**Addendum No. 1**

RE: Contract # C204041

**Johnston County (I-5786)**

I-95 From South Of SR-1001 (Lizzie Mill Road) To The Wilson  
County Line Just North of NC-222

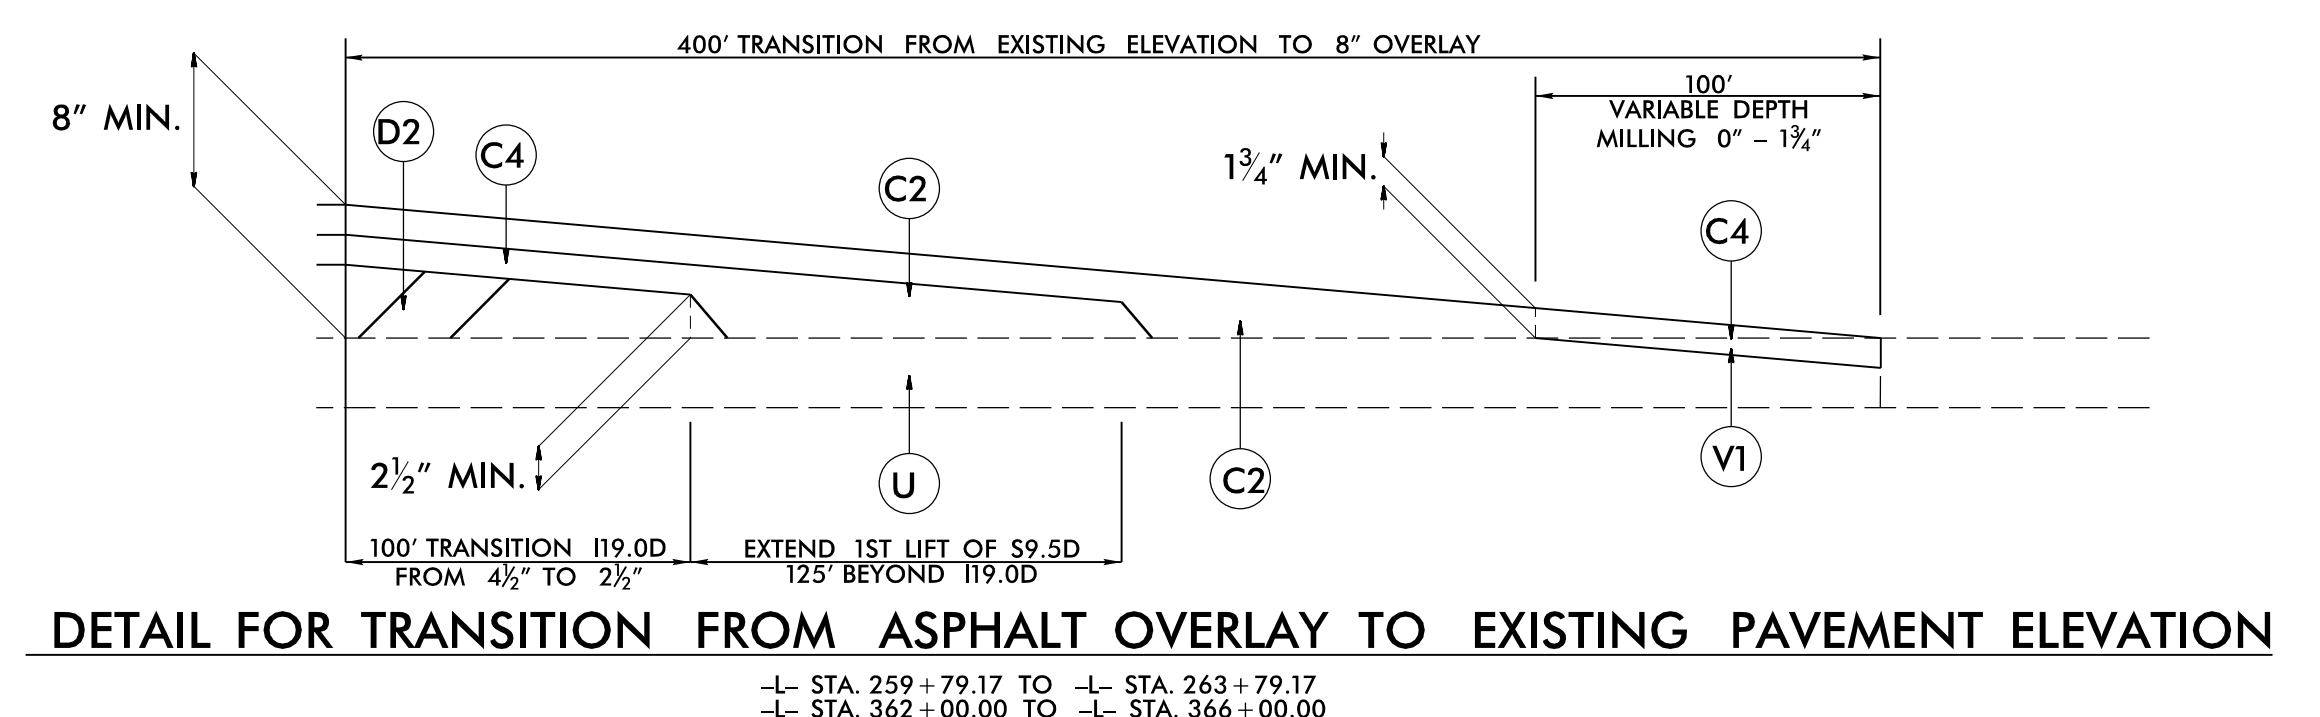
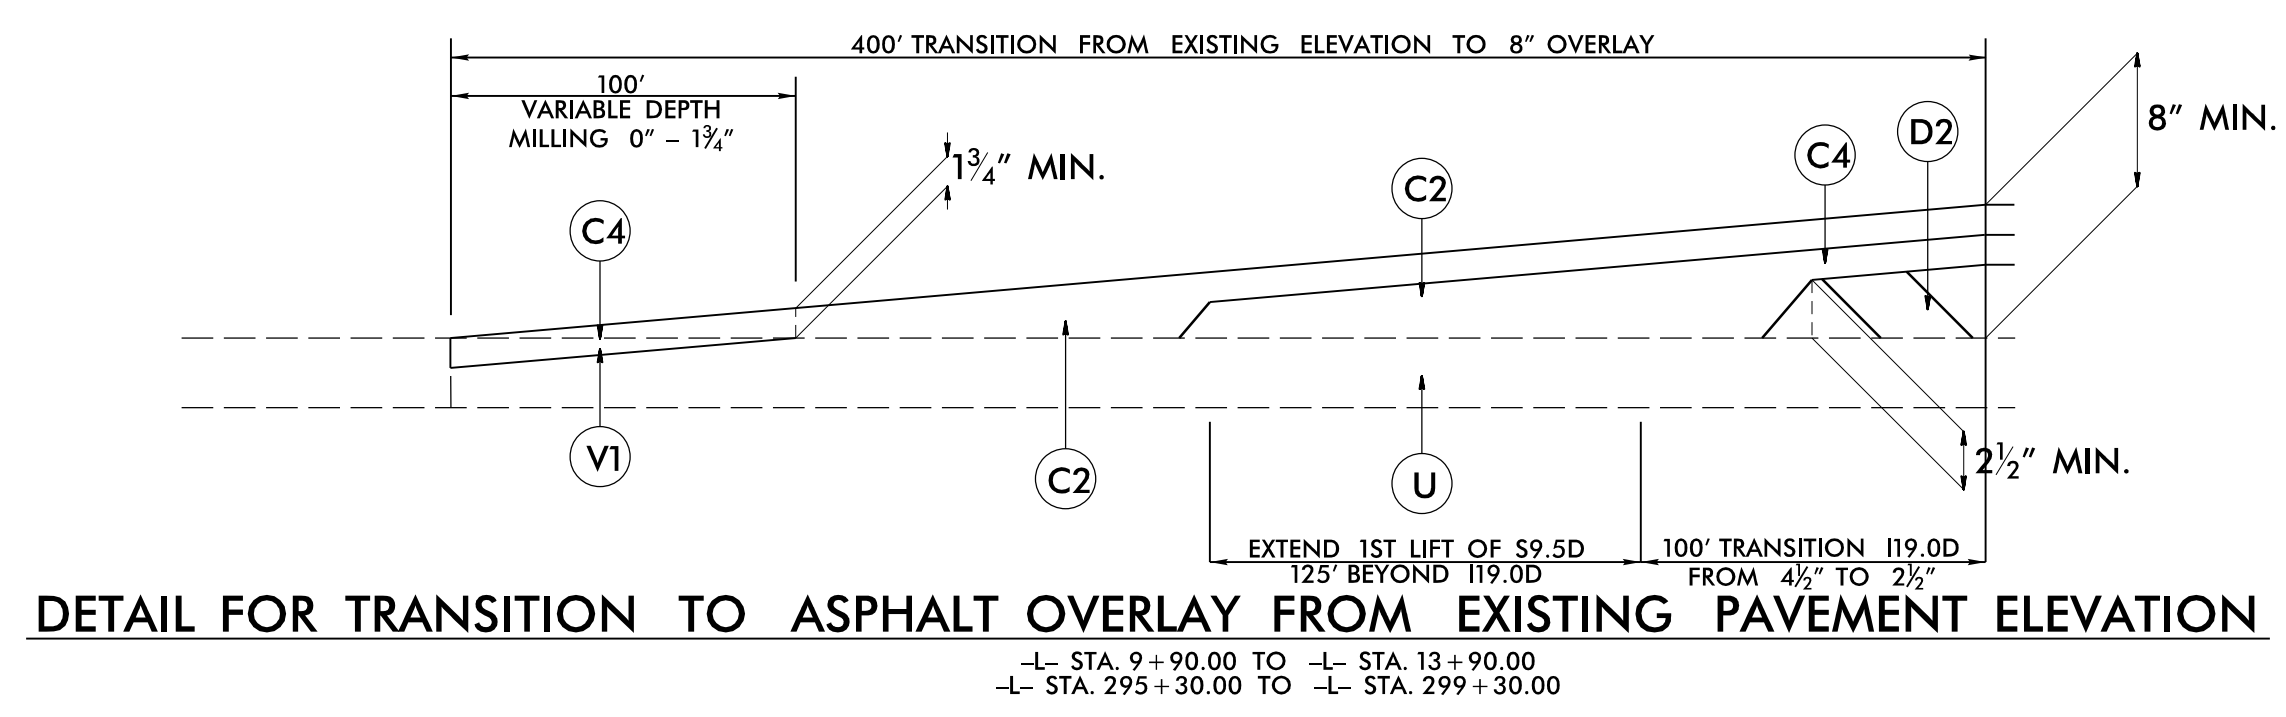
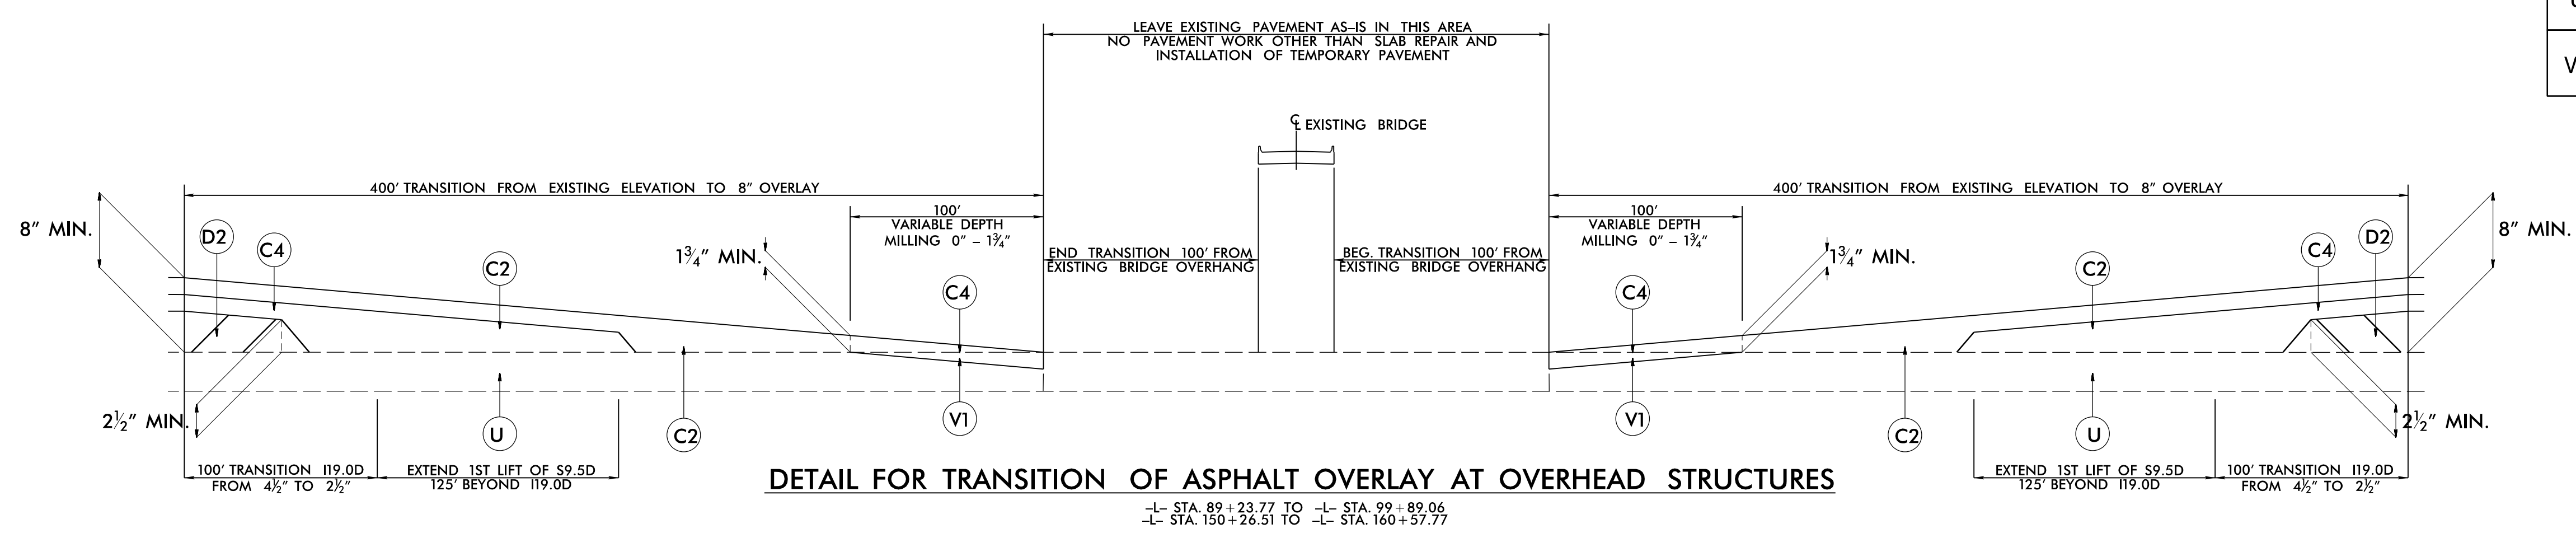
Sheet No.	Revisions
2A-2	Revised Typical Section No. 2 to correct the inside temporary pavement width
2B-1	Revised the station limits for Y3RPB
TMP-4 thru TMP-7, TMP-9 thru TMP-19 and TMP-28	Revised to reflect 8' temporary pavement width
